STATE OF NORTH CAROLINA
DEPARTMENT OF TRANSPORTATION

SUBJECT: Triangle Expressway Southeast Extension (Complete 540) from NC 55 Bypass in Apex to US 64/264 (I-87) in Knightdale, Wake and Johnston Counties; Federal Aid No. STP-0540(19), STP-0540(20), and STP-0540(21); WBS Nos. 37673.1.TA1, 35516.1.TA1, and 35517.1.TA1; STIP Project Nos. R-2721, R-2828, and R-2829

DEPARTMENT OF THE ARMY
U.S. ARMY CORPS OF ENGINEERS, WILMINGTON DISTRICT
RALEIGH FIELD OFFICE
3331 HERITAGE TRADE DRIVE SUITE 105
WAKE FOREST NC 27587

Reference the Department of the Army permit issued to the North Carolina Turnpike Authority, (NCTA) on October 24, 2019, and subsequently modified, to authorize the discharge of fill material into waters of the United States, for construction of the Triangle Expressway Southeast Extension (Complete 540) from NC 55 Bypass in Apex to US 64/264 (1-87) in Knightdale, Wake and Johnston Counties. Sections included within this permit are R-2721, R-2828, and R-2829.

SITE 14

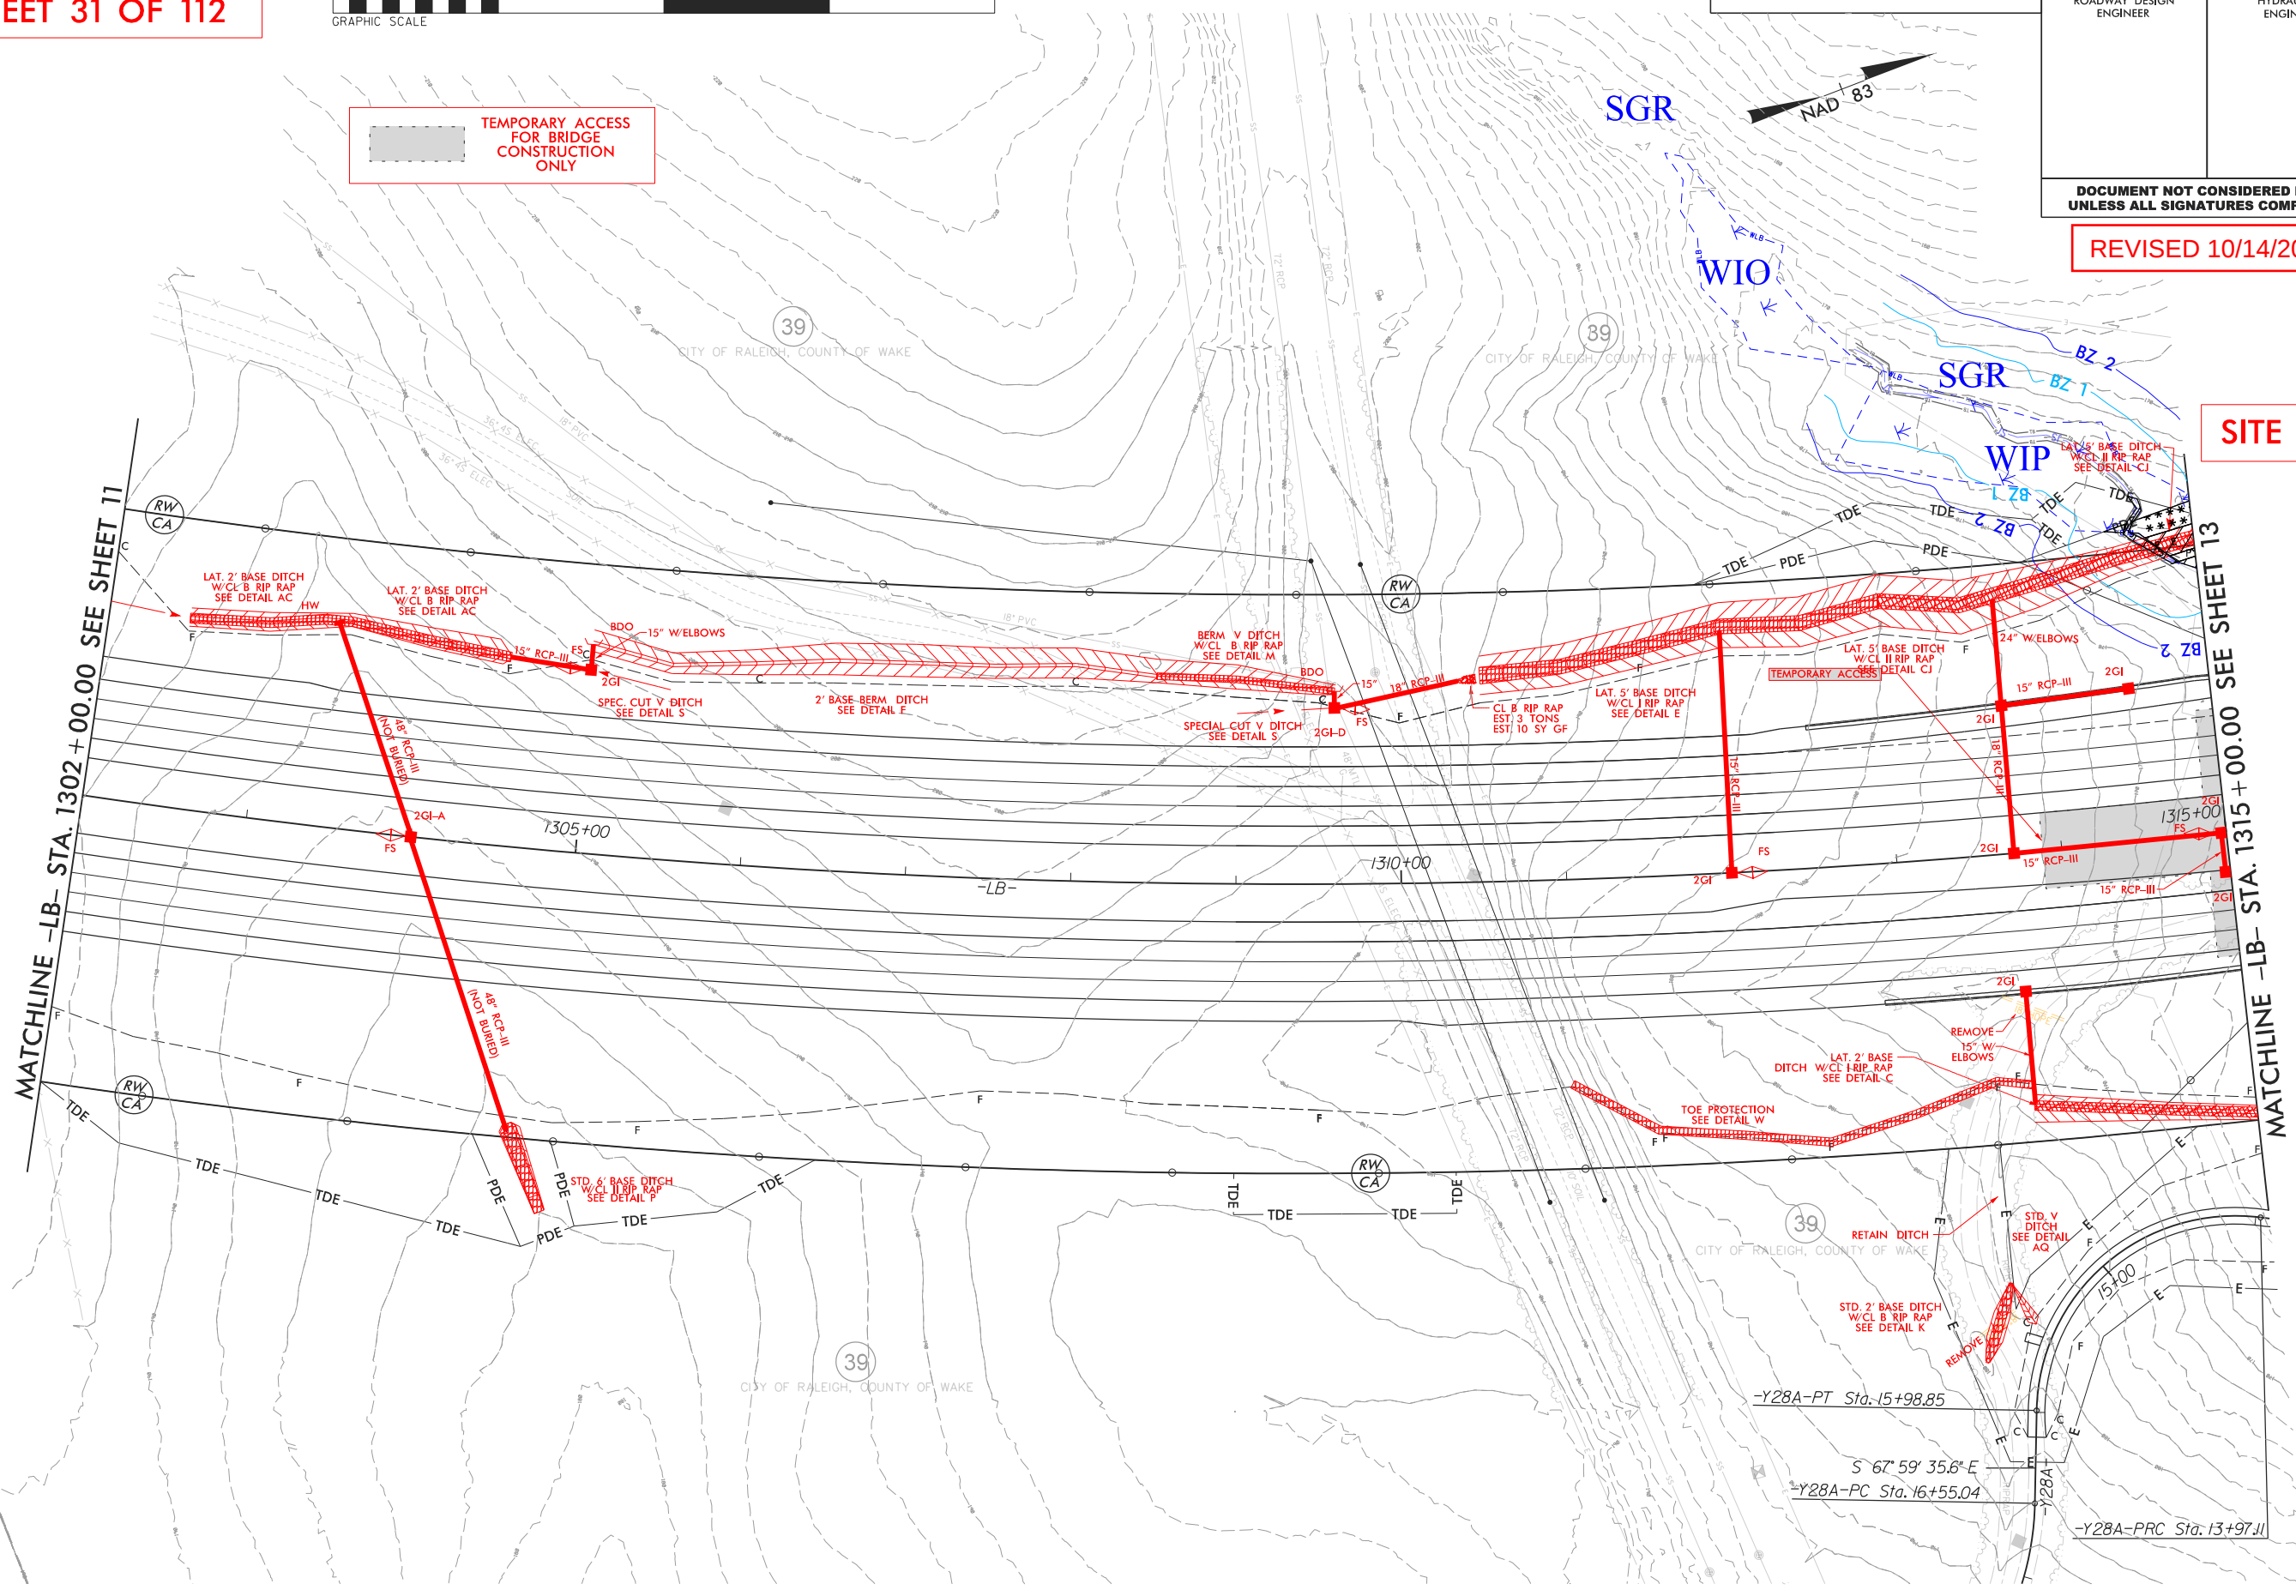
Also, please reference your November 25, 2025 email, requesting modification of the permit to authorize change of impacts at Permit Sites 14, 15, and 31, for R-2829B. The modifications at 14 and 15 are necessary for an alternate Neuse River bridge design that reduces the overall length of the bridge by 290 feet, saves approximately \$2 million in construction costs, reduces bridge construction time by 23 weeks (including short term impacts to the river and the Neuse River Greenway), and reduces required concrete truck trips by 262 loads.

Site 14: Impacts from southern end bent relocation

- Fill in Wetland: 0.036 ac (previously 0 - increase of 0.036 ac)
- Excavation in Wetland: 0.021 ac (previously 0.002 - increase of 0.019 ac)
- Mechanized Clearing in Wetland: 0.030 ac (previously 0.011 - increase of 0.019 ac)
- Permanent Surface Water Impacts: 500 lf (previously 442 - increase of 58 lf)
